**Project Location: Whataburger – Volcano Rd. & 98<sup>th</sup> St.**  
**DRB Project Number: PR-2019-002402**

Bowman Consulting is in receipt of the comments dated March 16, 2022, issued by City of Albuquerque for the Whataburger restaurant at NEC of Volcano Rd. & 98<sup>th</sup> St, Albuquerque, NM 87121. Please see below for the responses to the comments:

## Transportation Development - Engineering Comments

DESIGN: BB, DRAWN: BB, CHKD: KAN
 JOB NO. 070426-01-001
 SHEET C006

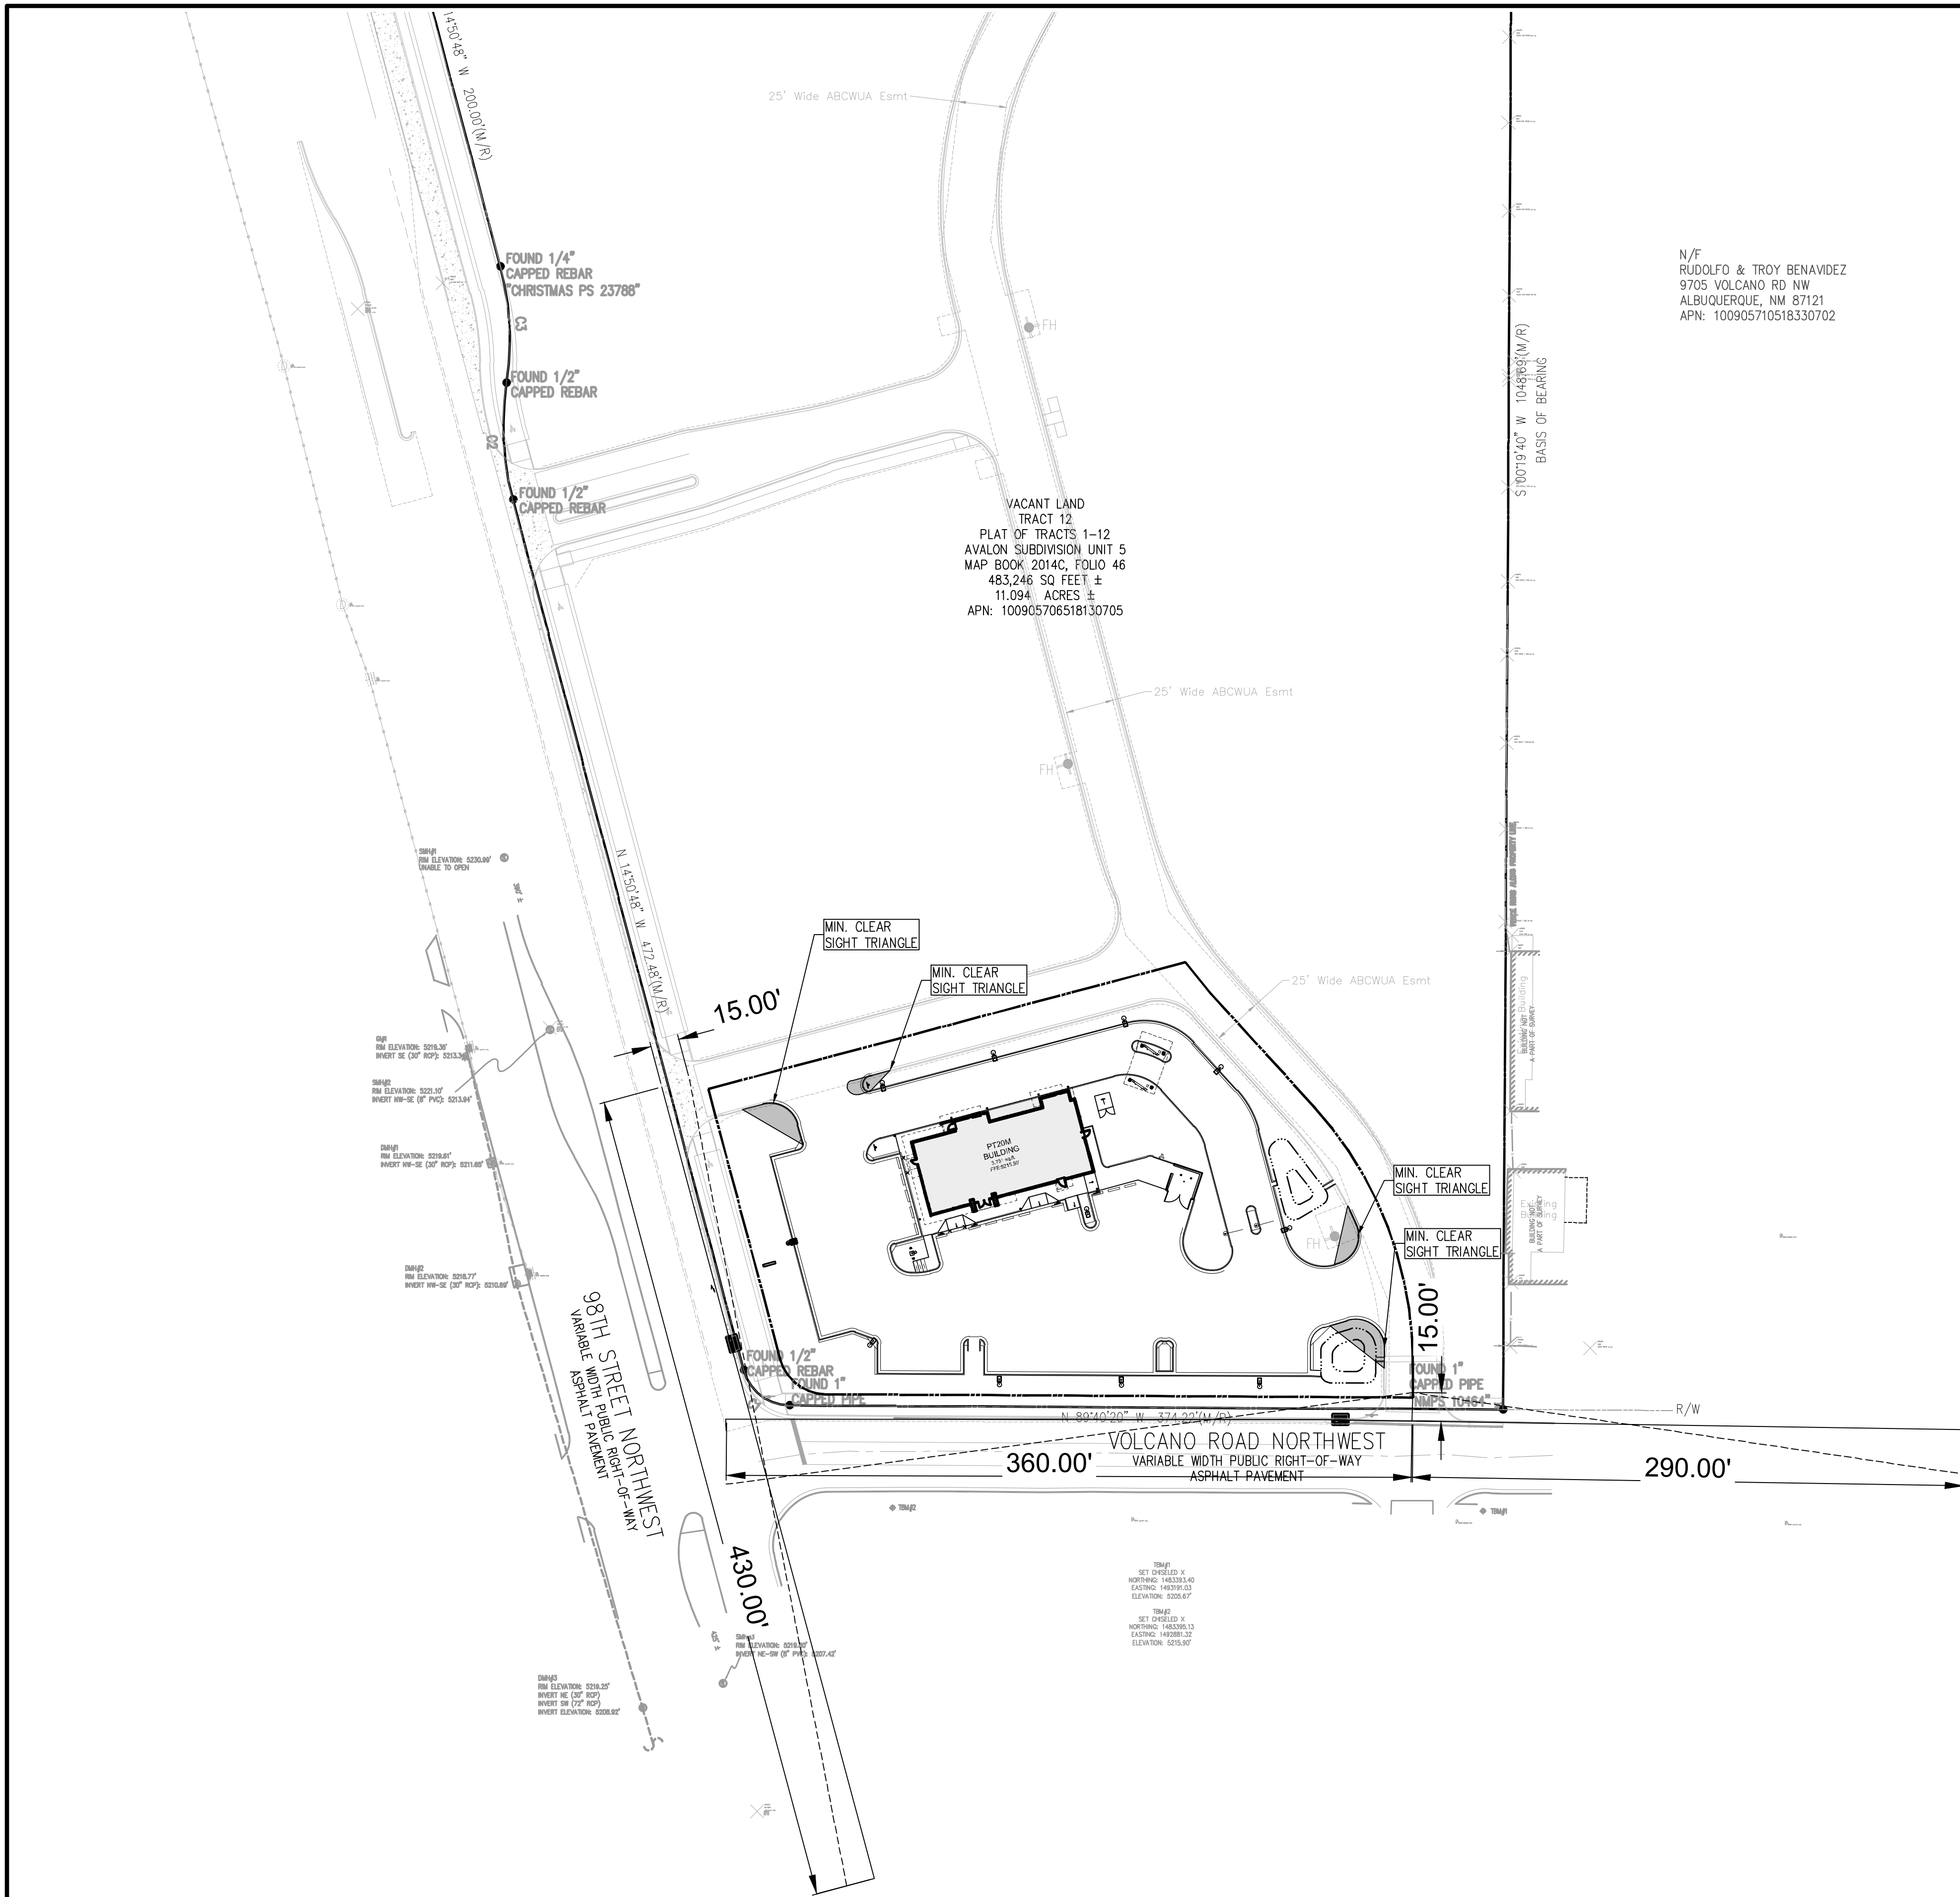
- Comment 1:** Add a bold note that the accessways surrounding site and public roadway improvements shall be built per work order. The accessway shall be in place prior to Certificate of Occupancy.

**Response: Note has been added.**
- Comment 2:** For the one-way aisle within the drive-thru directional arrows on the pavement for the site plan. Also, add a One-way sign.

**Response: One-way aisle drive-thru directional arrows and one-way signs have been added see key note 2D.**
- Comment 3:** For the handicapped ramp at the accessible aisle, ensure that there is a minimum 4-foot dimension between the wing of the ramp and the corner of the building. (Add a dimension at the pinch point around the main entrance.)

**Response: Minimum 4ft. dimensions have been labeled to show clearance between building corner and ramp.**
- Comment 4:** Indicate a maximum 2% cross-slope on the sidewalk detail. Also, on the site plan, indicate which type of curb shall be used.

**Comment 6:** Dimension the parking aisle south of the building at different locations where the width varies, and also include a dimension at the entranceway. Also, dimension the 6-foot ADA pathway to Volcano Road.

**Response: 2% cross-slope minimum labels have been added to sidewalk detail and site plan. Curb type has been labeled; see key notes.**
- Comment 5:** On 98th Street and Volcano, use a clear sight triangle for intersection sight distance to be sure that there are no conflicts with the proposed landscaping. Add the note "Landscaping, fencing and signing will not interfere with clear sight requirements. Therefore, signs, walls, trees, and shrubbery between 3 and 8 feet tall (as measured from the gutter pan) will not be acceptable in the clear sight triangle."

**Response: Parking aisle, entranceway and ADA pathway dimensions have been labeled.**
